Our ref: DOC19/661604
Senders ref: SSD 9394

Subject: Baiada integrated poultry processing facility SSD 9394

Thank you for your email dated 23 July 2019 seeking comment from North West Biodiversity and Conservation Division (BCD) on the proposed Baiada integrated poultry processing facility.

Drawing Name:
**Landscape
Tree Masterplan**

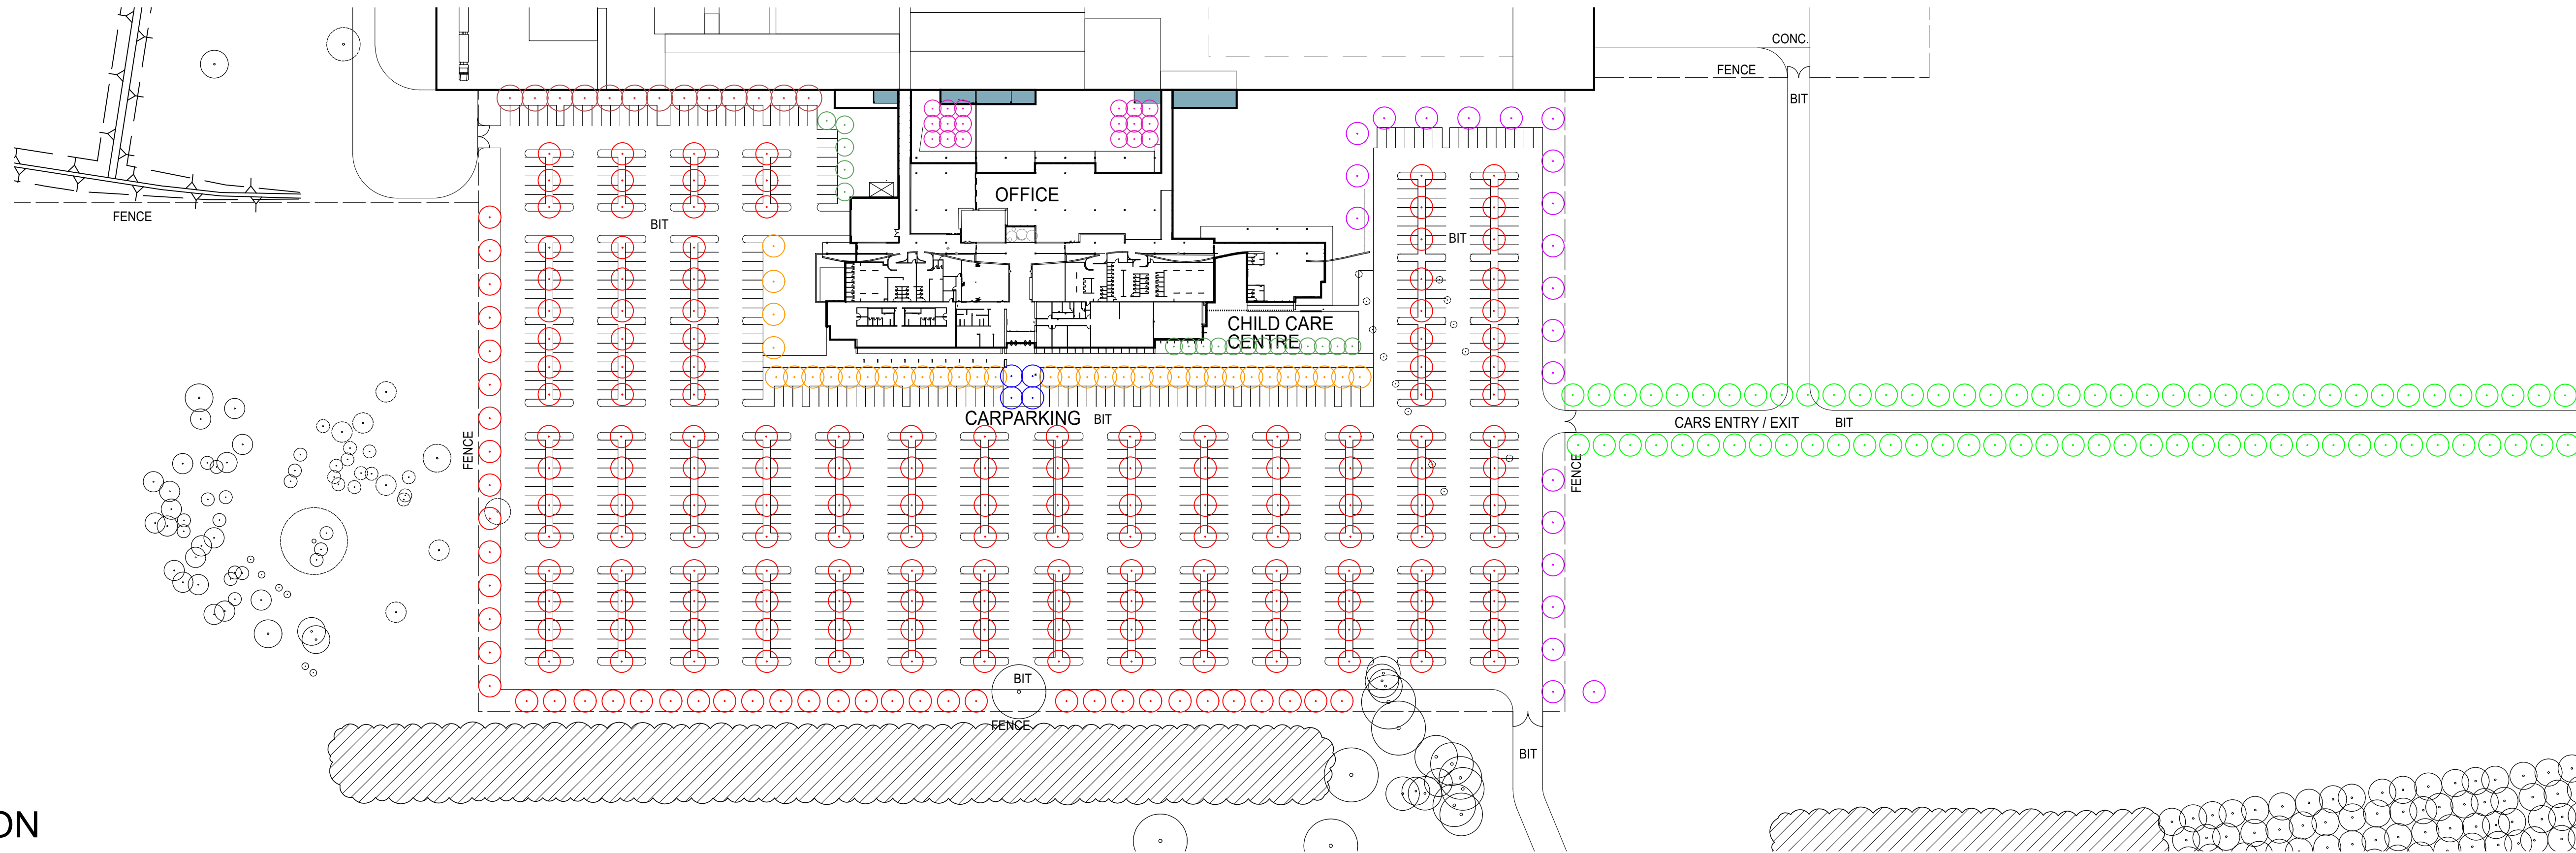
The landscaping concept plan (appendix 5) shows an intent to landscape with exotic and non-indigenous species. BCD recommends that species used for landscaping and screening be commensurate with PCT 599 and be germinated from locally sourced seed.

Plant species used for landscaping and screening be commensurate with PCT 599 and be germinated from locally sourced seed.
